AMENDMENT RECORD SHEET - LIVE APPLICATION

PLANNING AMENDMENT

33 STATION ROAD, LONG SUTTON.

Re: Application No. H11/0714/0701
Mr. and Mrs. D. Dye, 33 Station Road, LONG SUTTON

1:500 SCALE DRAWING
33 STATION ROAD, LONG SUTTON
SHOWING A DETACHED HOUSE AND TWO
DETACHED BUNGALOWS REPLACING
WAREHOUSE AND YARD

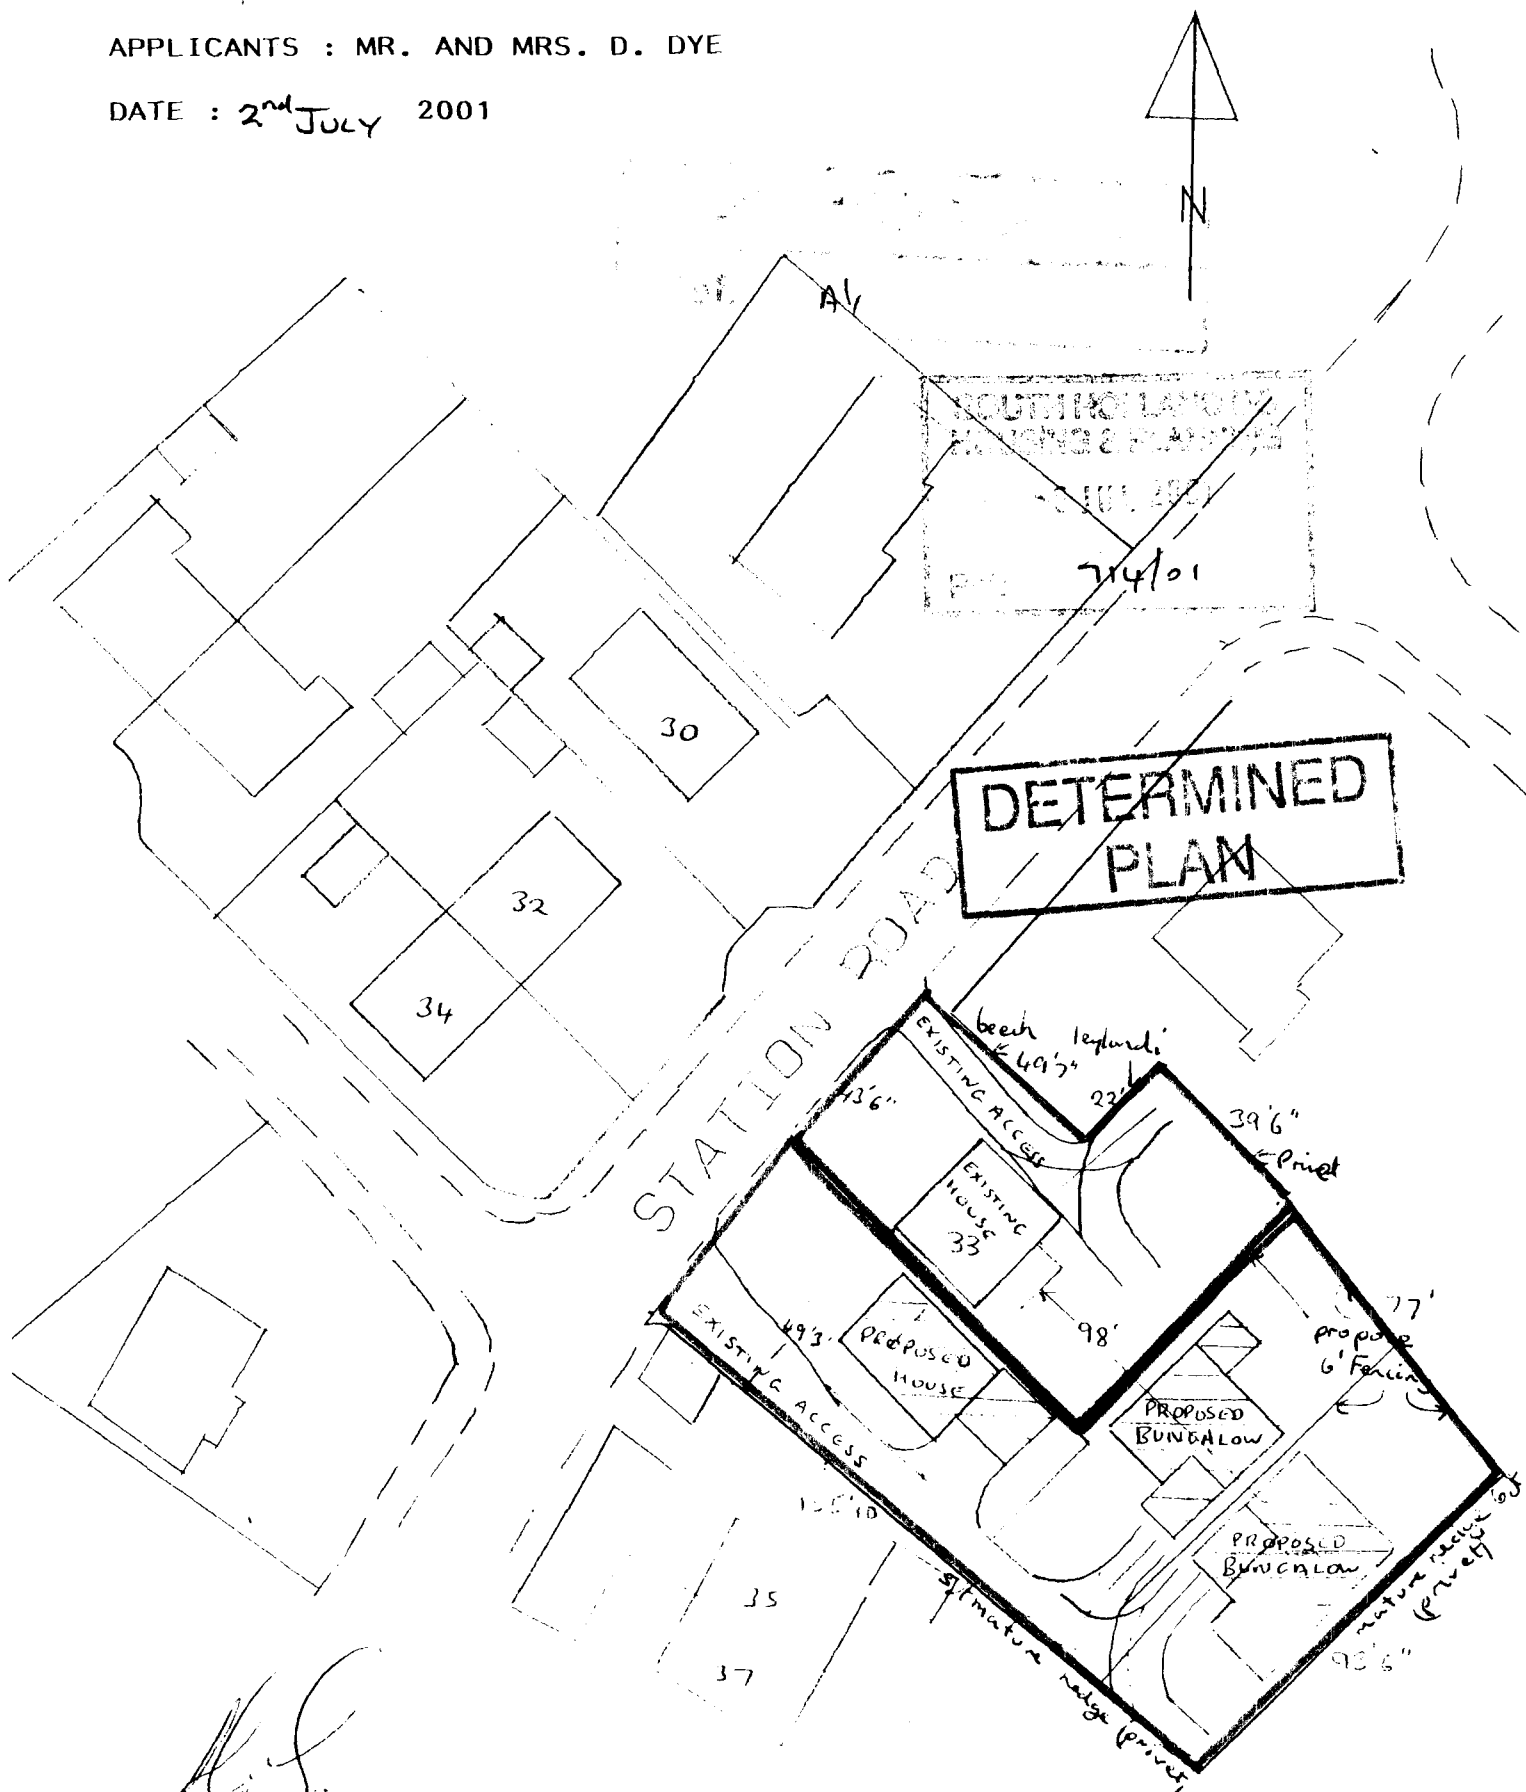
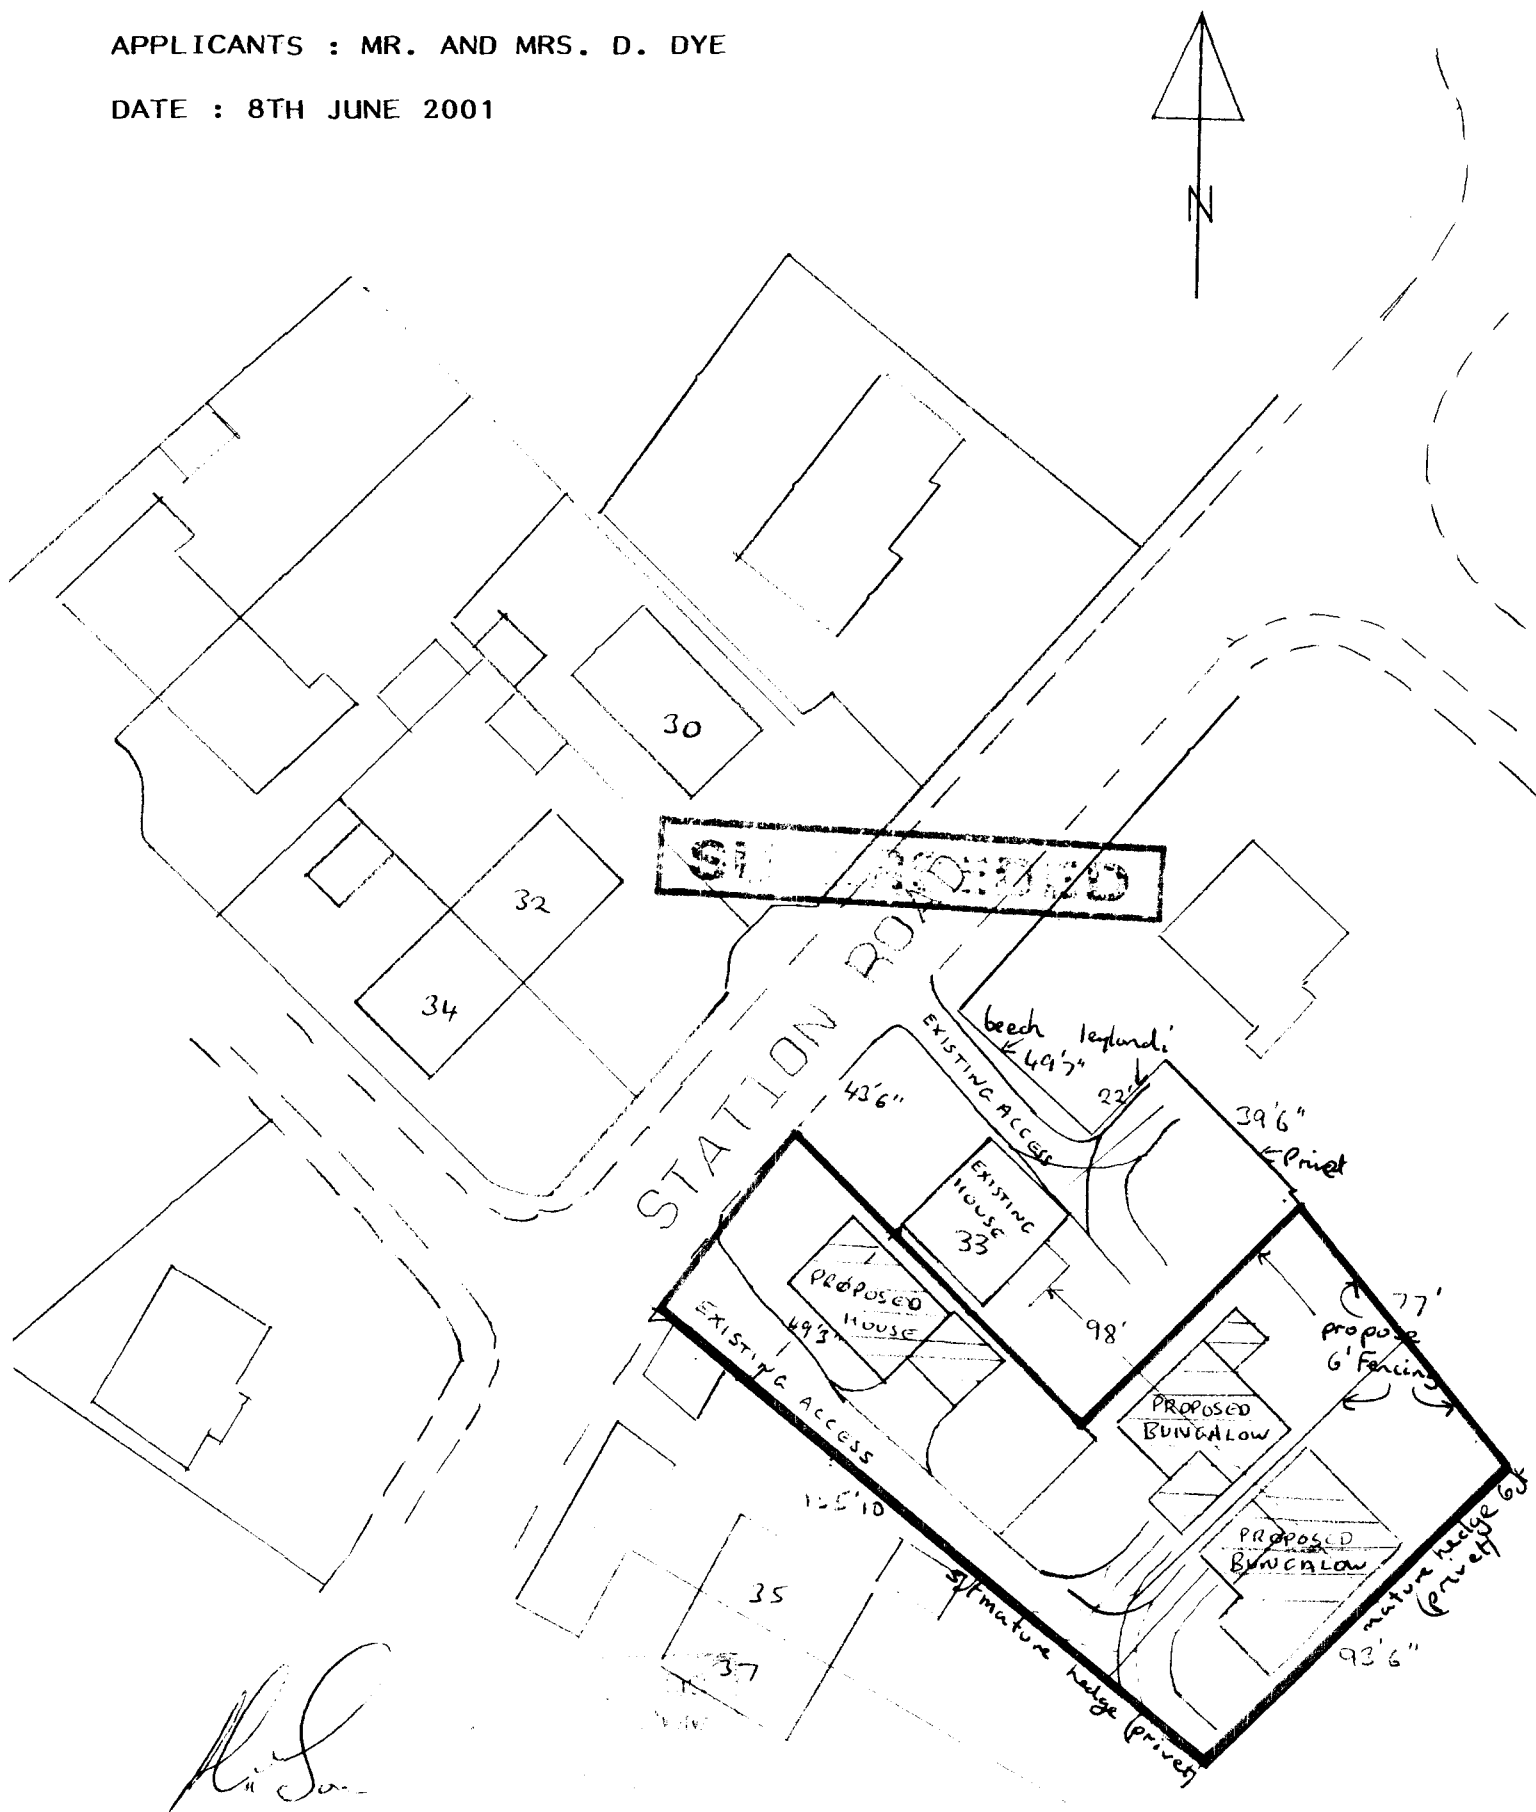
REPOSITION HOUSE FURTHER BACK FROM THE DYKE

He indicated that provided the proposed house is behind the established building line with Nos. 35 and 37 and the corner of No. 33 he would give the application his recommendation. We have therefore amended our application by moving the house further back from the dyke and enclose herewith a fresh set of 6 plans dated 2nd July to replace those dated 8th June.
